## ASSESSMENT REPORT

### Section 75W Modification Fern Bay Seaside Village, Fern Bay MP 06\_0250 MOD 9

This report is an assessment of a request to modify the Project Approval (MP 06\_0250) for a community title residential subdivision at Fern Bay in the Port Stephens local government area. The request has been lodged by Fern Bay No. 1 Pty Ltd (the Proponent) pursuant to section 75W of the *Environmental Planning and Assessment Act 1979* (EP&A Act). It seeks to modify the approved northern access road from a local road to gated emergency only access, delay the provision of the road, revise the subdivision layout and subdivide super lots in Stages 18-20 into 40 residential lots.

CUT (-ve) & FILL (+ve) DEPTHS DATA			
NUMBER	DEPTH	DEPTH	COLOUR
1	-11.1	-10.0	
2	-10.0	-8.0	
3	-8.0	-6.0	
4	-6.0	-4.0	
5	-4.0	-2.0	
6	-2.0	0.0	
7	0.0	2.0	
8	2.0	4.0	
9	4.0	6.3

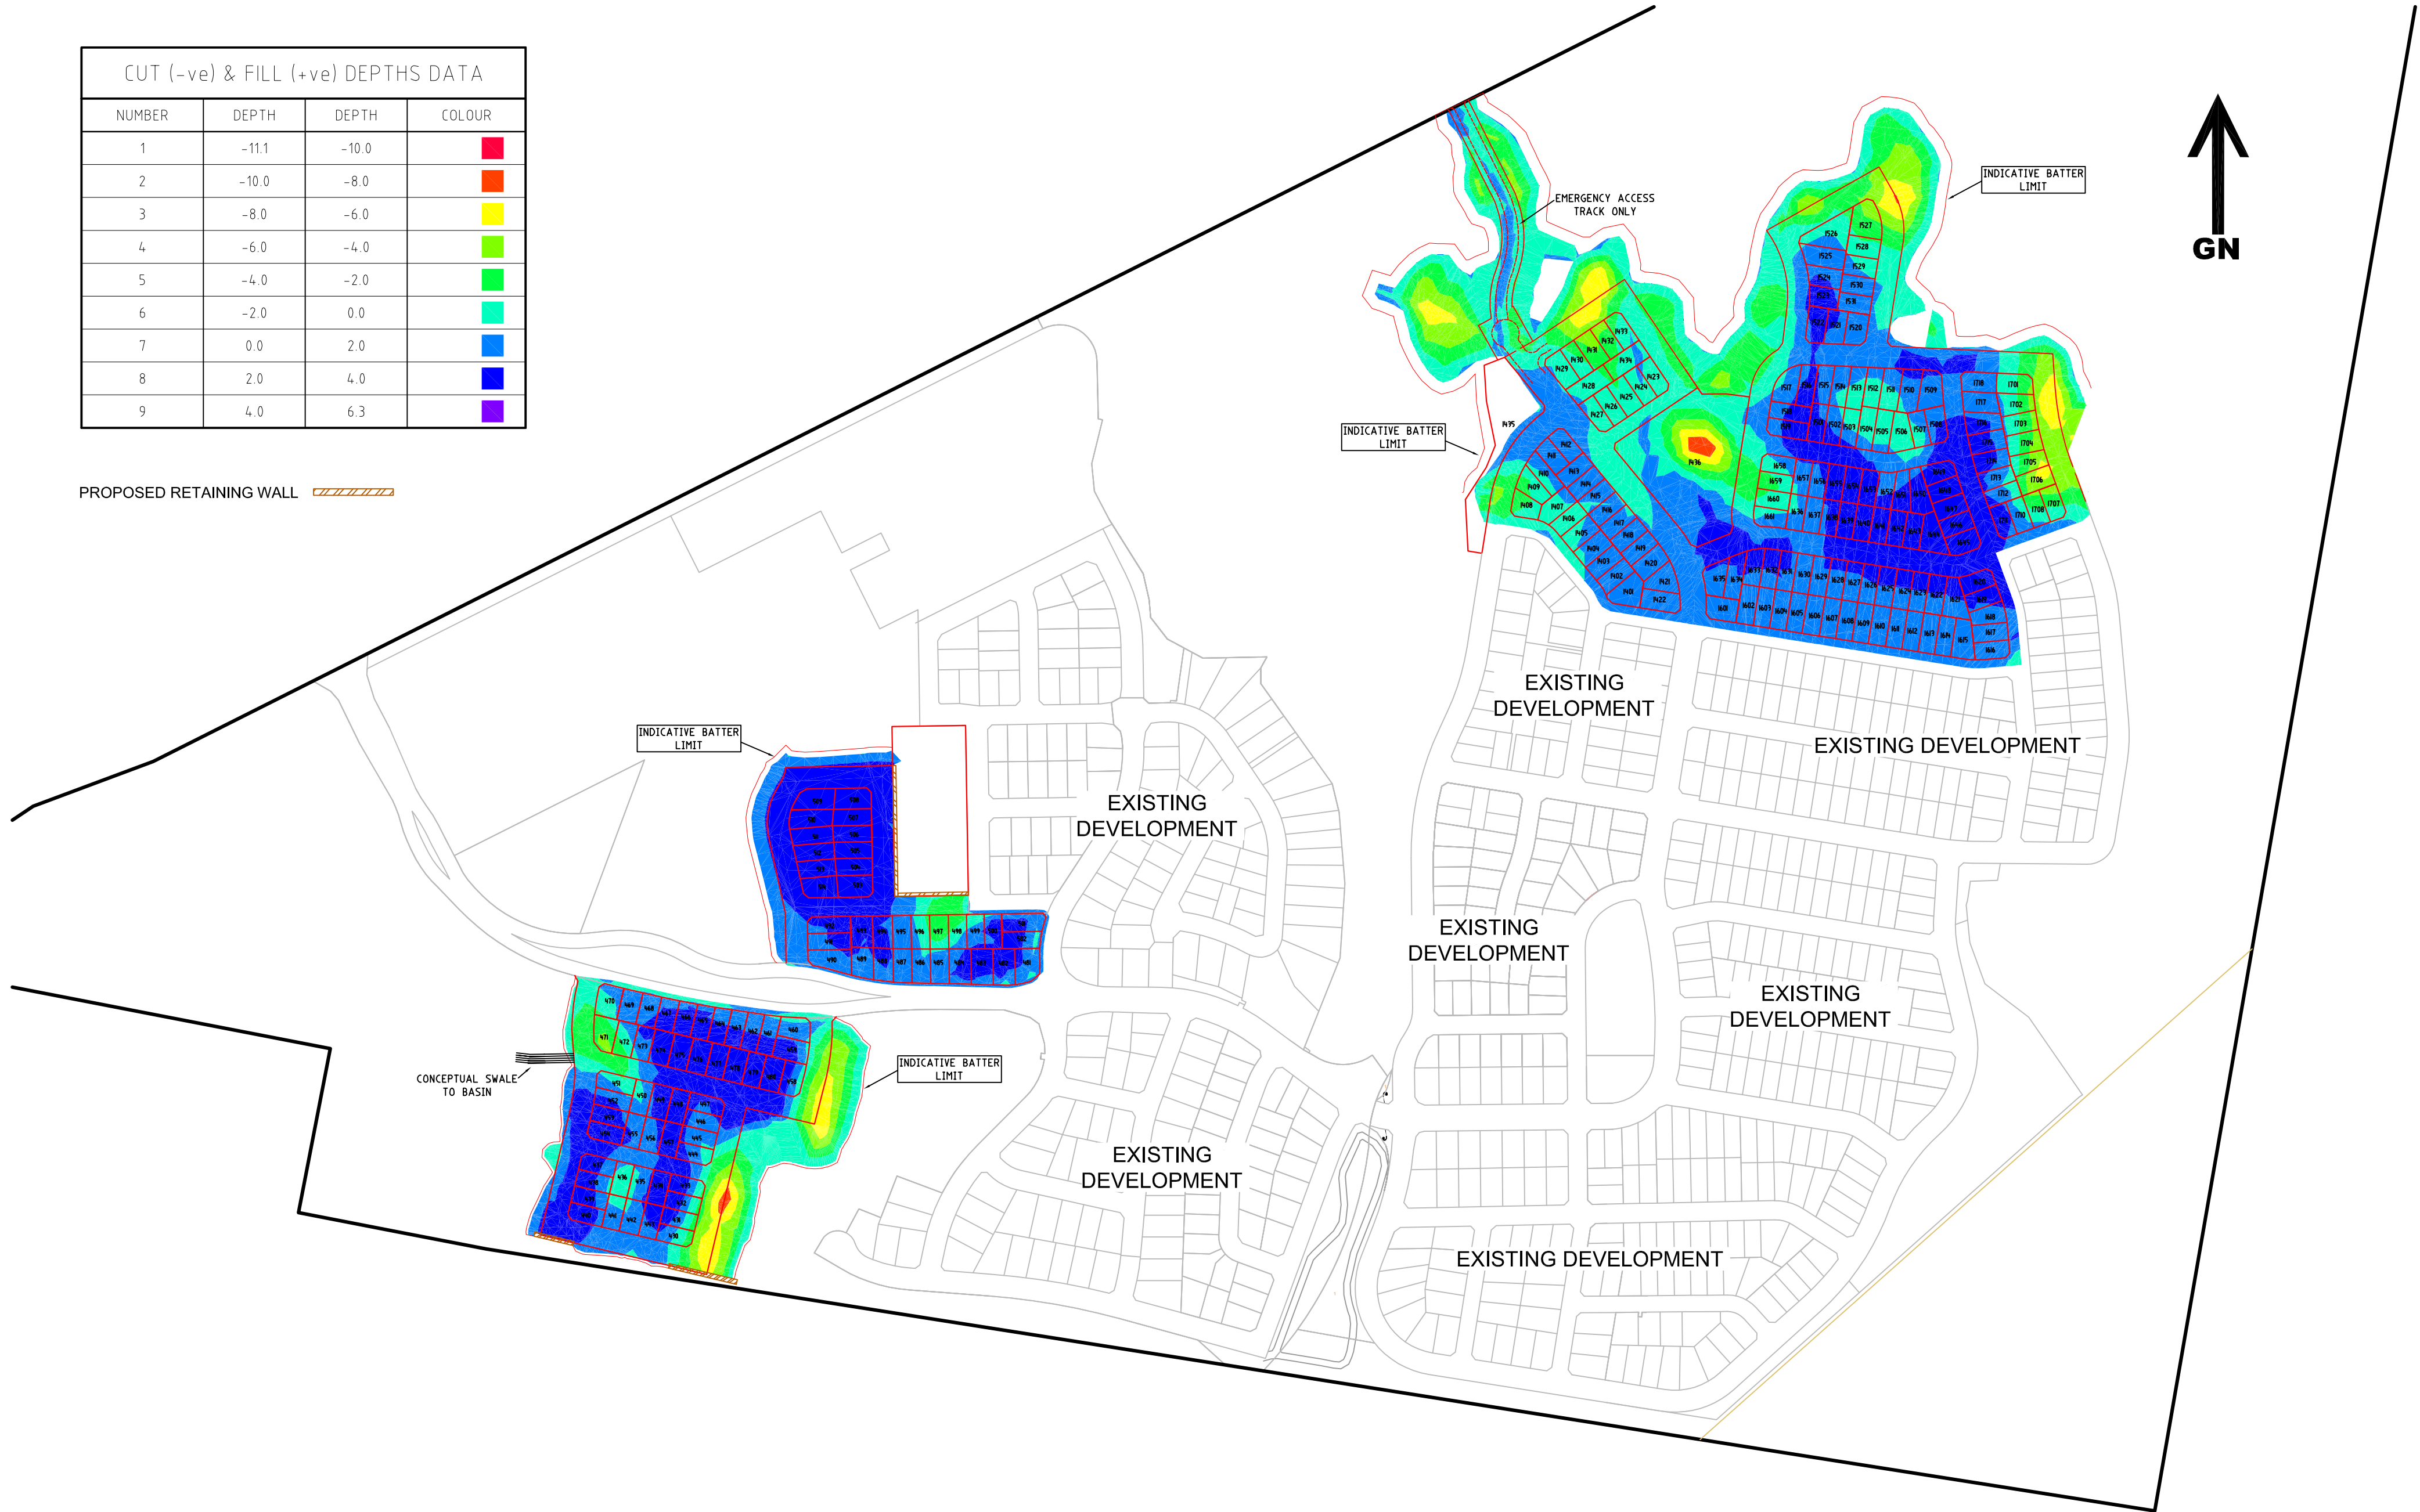
The Department notes the proposal incorporates significant areas of excavation within the E2 Conservation Zone, with excavation depths exceeding 8 metres (**Figure 9**). This is a significant variation from the approved design, which does not incorporate any bulk earthworks within or in close proximity to the E2 Conservation Zone (**Figure 8**). The Proponent has not provided any justification for the proposed change or any assessment of the biodiversity impacts of the proposed clearing and excavation.

Given the potential ecological and biodiversity impacts associated with the clearing and excavation, the Department does not support the proposed change. Given the approved subdivision layout has a similar development footprint to the proposed layout, and did not require such extensive bulk earthworks, it is considered that the proposed layout should be provided without any earthworks encroaching on the E2 Conservation Zone. A condition is therefore recommended, requiring a revised bulk earthworks design which does not encroach on the E2

Conservation Zone, to be approved prior to the issue of a Construction Certificate for Stages 18 or 19.
